GREY HOUSE PRECINCT,  
PYMBLE LADIES' COLLEGE

SSD-17424905

Architectural Design Report  
Addendum

05. 04. 22

1 SHADOW DIAGRAM PROPOSED June 21 - 5PM
1 : 1000

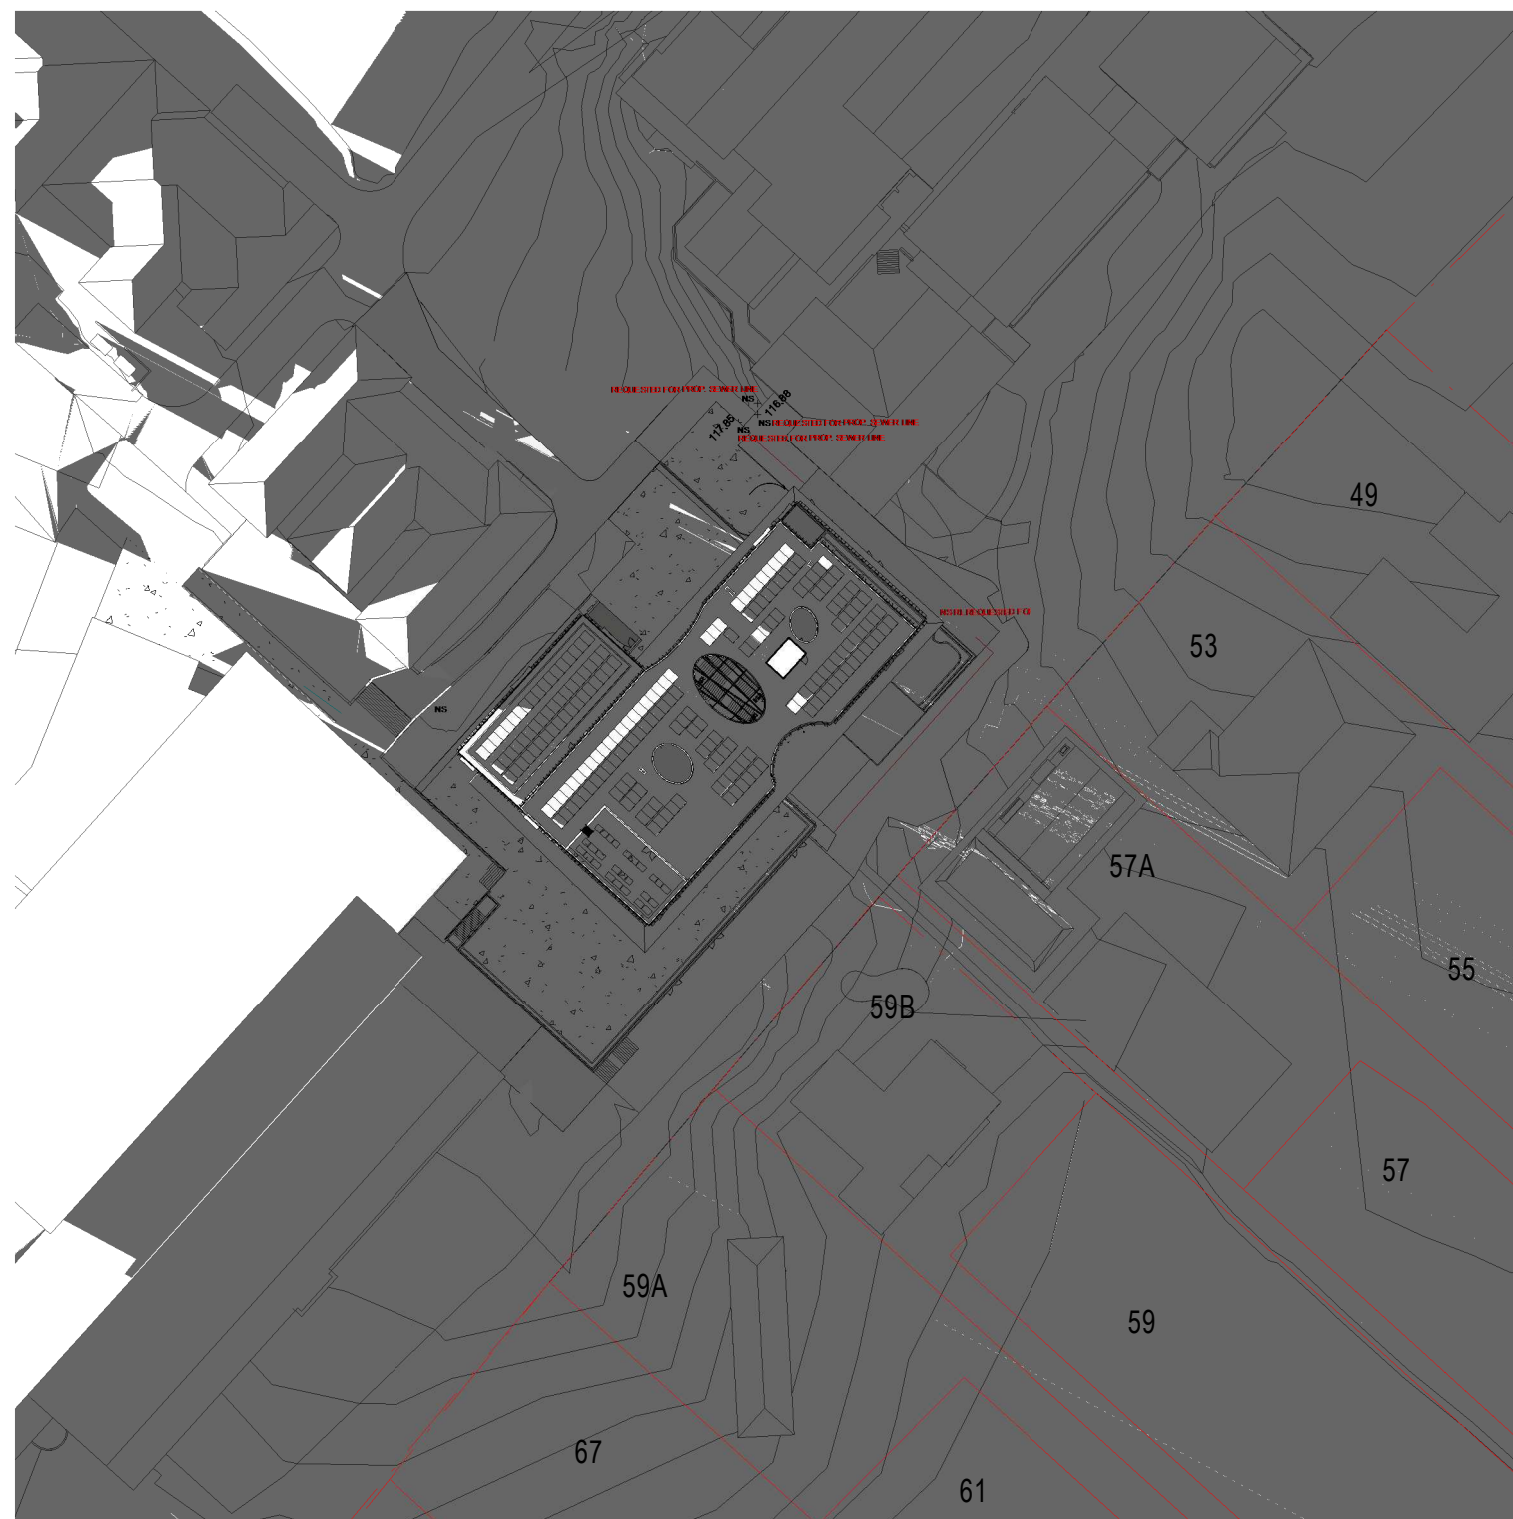
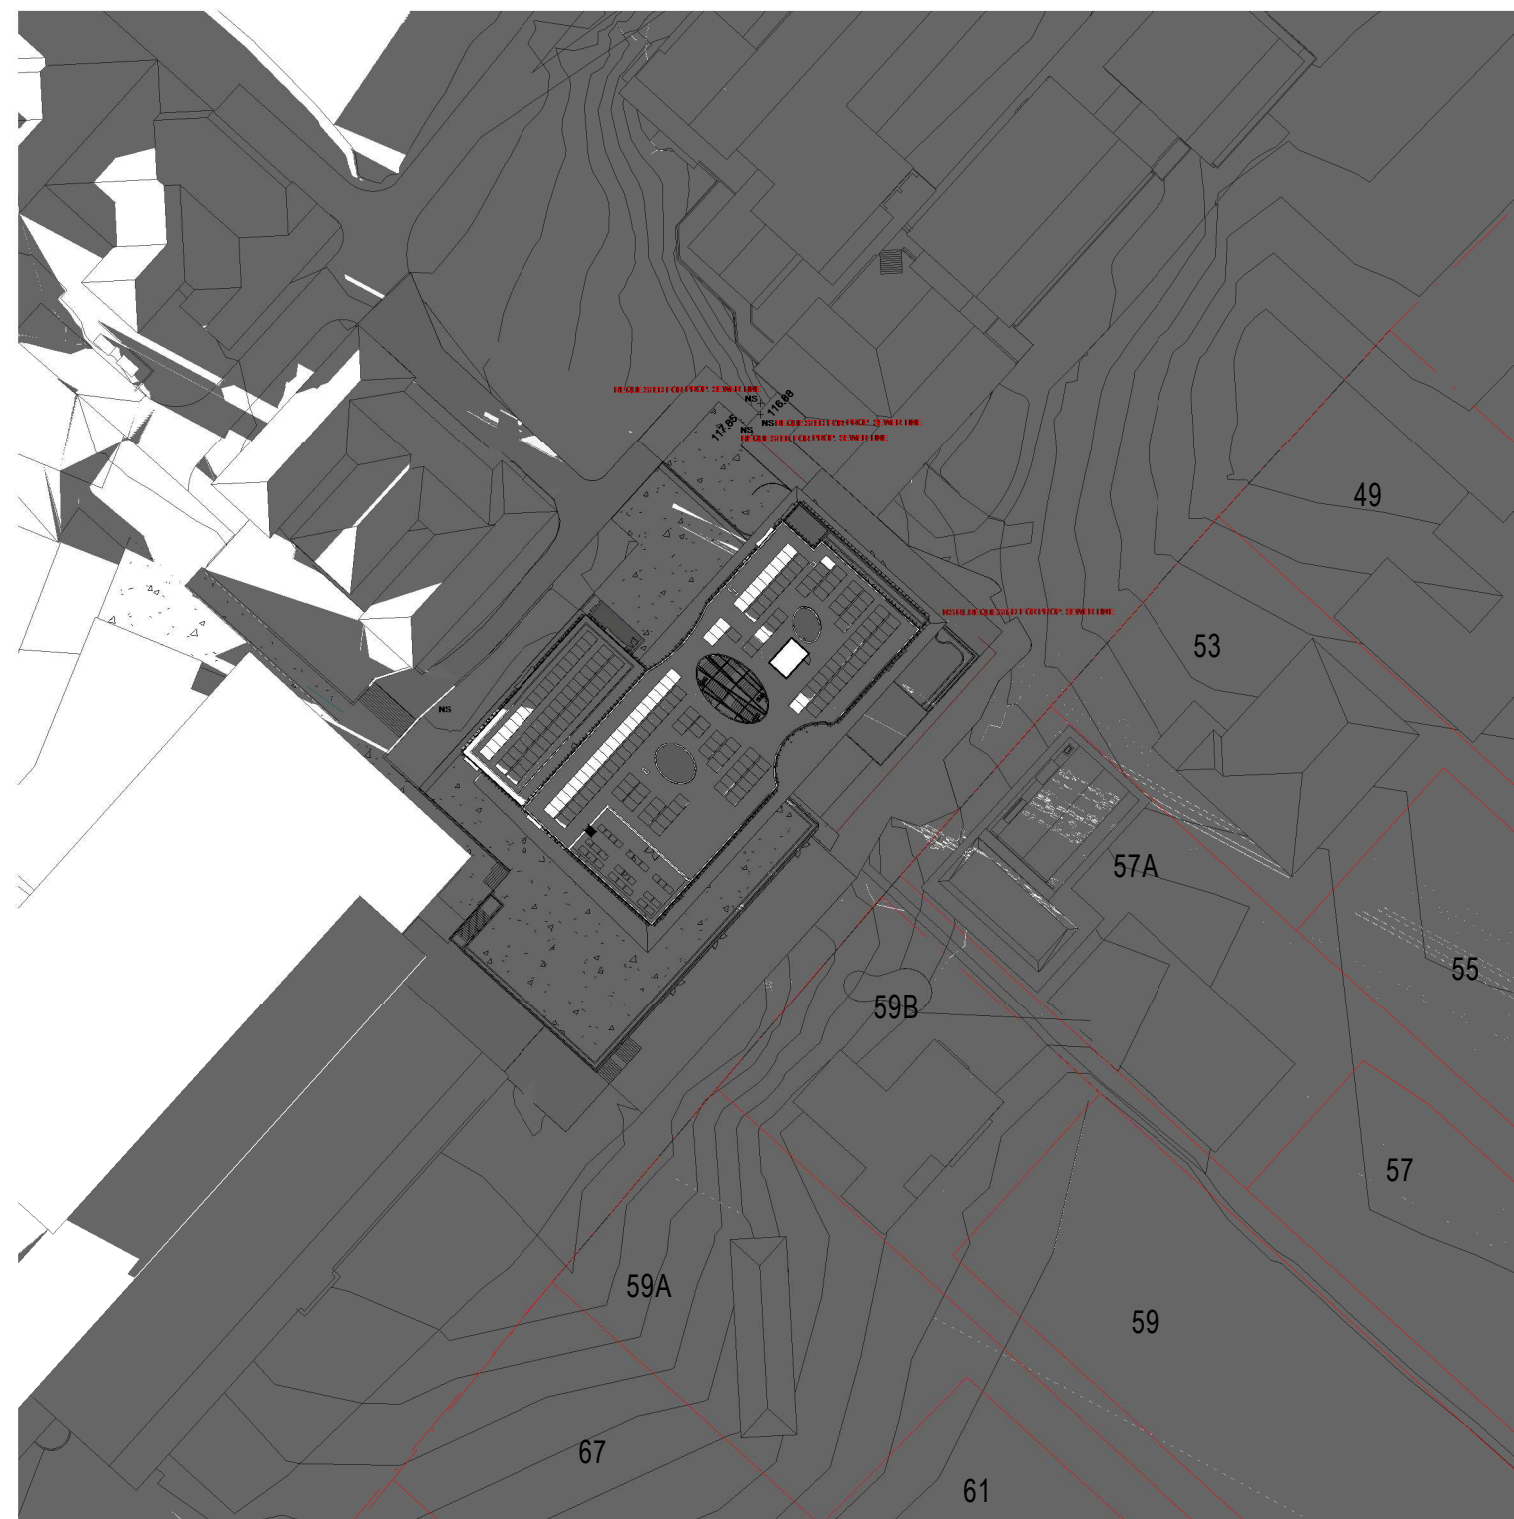
11. Clarify the impact of the proposal on the solar access of the adjoining properties, as this has not been clearly demonstrated. Provide existing and proposed diagrams identifying the quantum of solar access to the living area glazing and the principal private open space of affected properties to demonstrate if a reasonable level of solar access will be maintained for the adjoining properties.

This report includes solar access analysis of the impact of the Grey House Precinct to the adjoining residential properties.
